Your ref 3/2023/0930
Our ref DC/23/4294
Date 05-JAN-24

Location: Clayton Manor Ribchester Road Wilpshire Lancashire BB1 9HU

Proposal: Proposed construction of four one-bedroom apartments in a purpose-built detached building

OBJECTION – SEWER INFRASTRUCTURE

Drawing Title
PROPOSED CLAYTON MANOR LODGE SITE LAYOUT

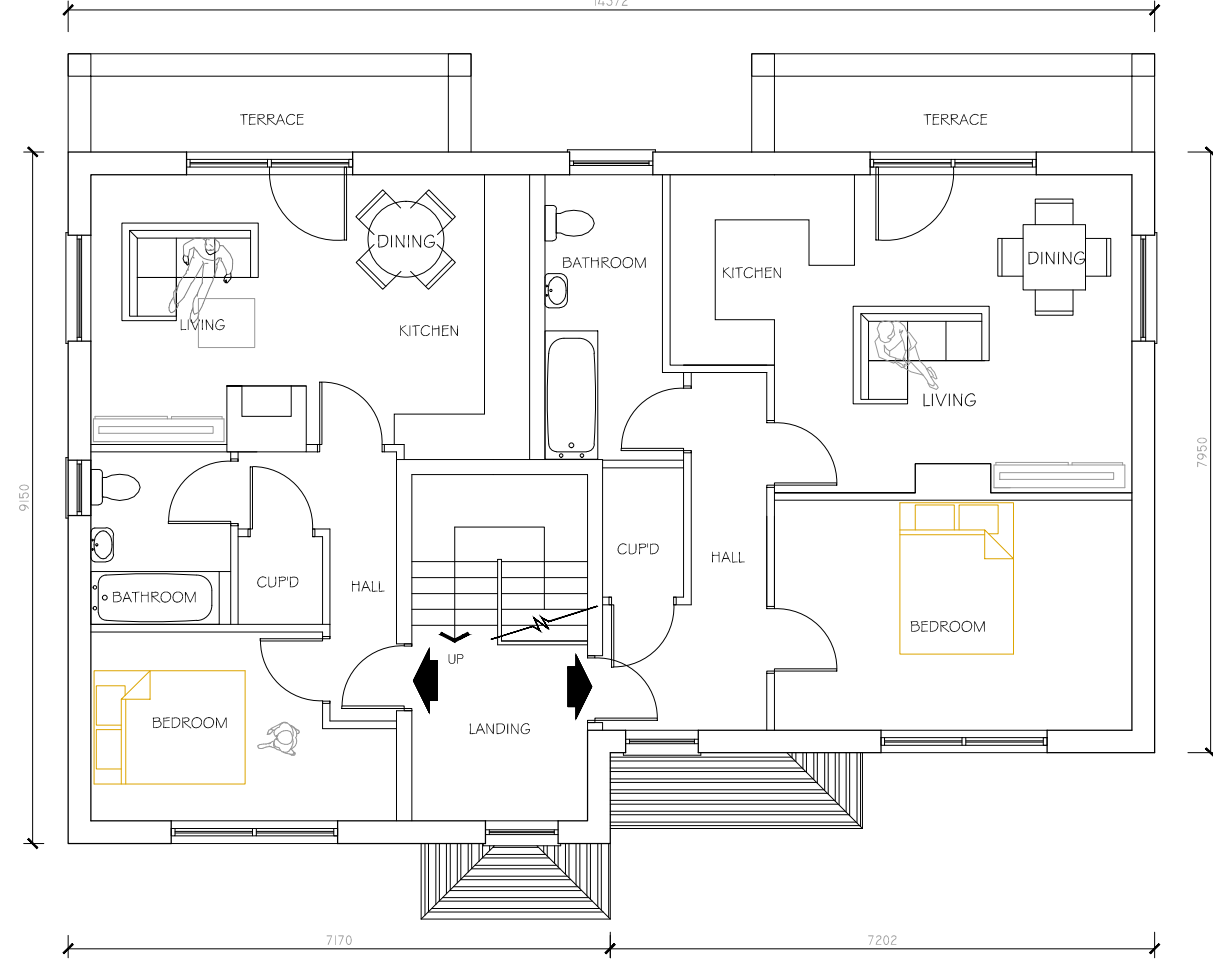
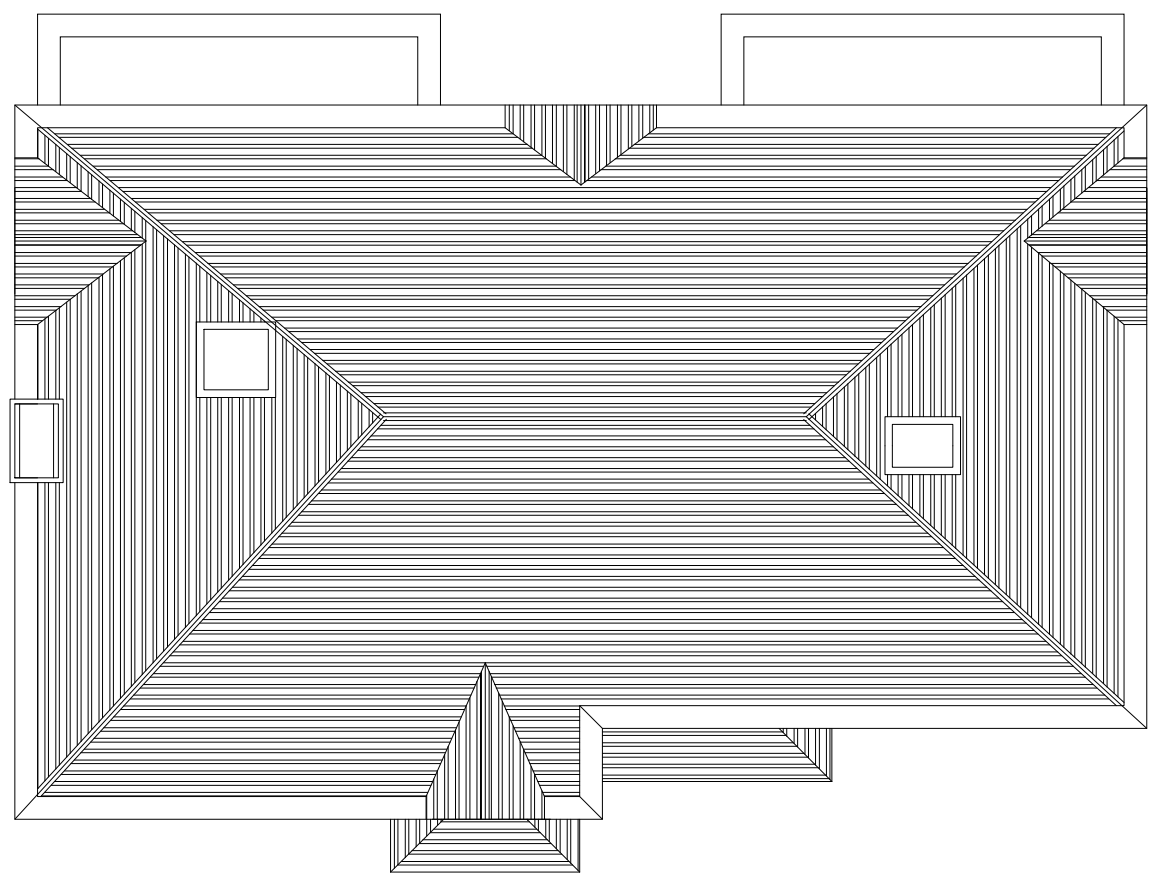
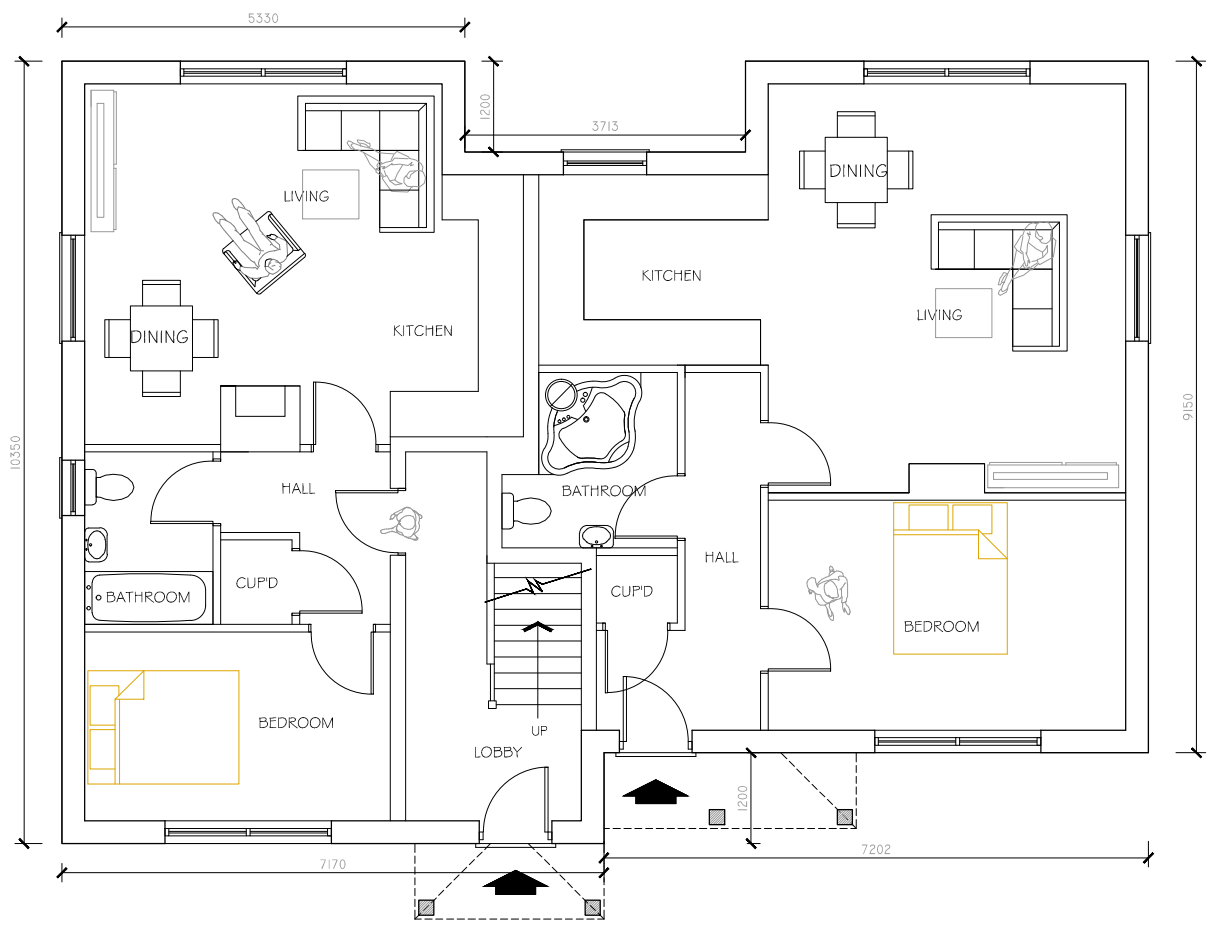
Proposed features appear to be located above an existing sewer. Until such time as the applicant has resolved all concerns regarding the proximity of proposed development to our asset(s), our position is that we must **OBJECT** to the proposal.

Following our review of the submitted drainage documents; proposed site layout, prepared by Philip Heaton Associates Ltd, Ref: 2101-, Dated 24-01-23, the plans are not acceptable to United Utilities. This is because we have not seen robust evidence that the drainage hierarchy has been thoroughly investigated and the proposals are not in line with the Non-Statutory Technical Standards for Sustainable Drainage Systems.

As noted above, a public sewer crosses the site and we will not permit building over it. We require an access strip for maintenance or replacement and this access must not be compromised in any way. The minimum distances that might be acceptable to United Utilities are detailed within Part H of the Building Regulations however, we recommend the applicant determines the precise location, size, depth and condition of the pipeline as this is likely to influence the required stand-off distance from any structure

Prior to the commencement of development, details of a sustainable surface water drainage scheme and a foul water drainage scheme shall be submitted to and approved in writing by the Local Planning Authority. The drainage schemes must include:

- (i) An investigation of the hierarchy of drainage options in the National Planning Practice Guidance (or any subsequent amendment thereof). This investigation shall include evidence of an assessment of ground conditions and the potential for infiltration of surface water in accordance with BRE365;*
- (ii) A restricted rate of discharge of surface water agreed with the local planning authority (if it is agreed that infiltration is discounted by the investigations);*
- (iii) Levels of the proposed drainage systems including proposed ground and finished floor levels in AOD;*
- (iv) Incorporate mitigation measures to manage the risk of sewer surcharge where applicable; and*
- (v) Foul and surface water shall drain on separate systems.*
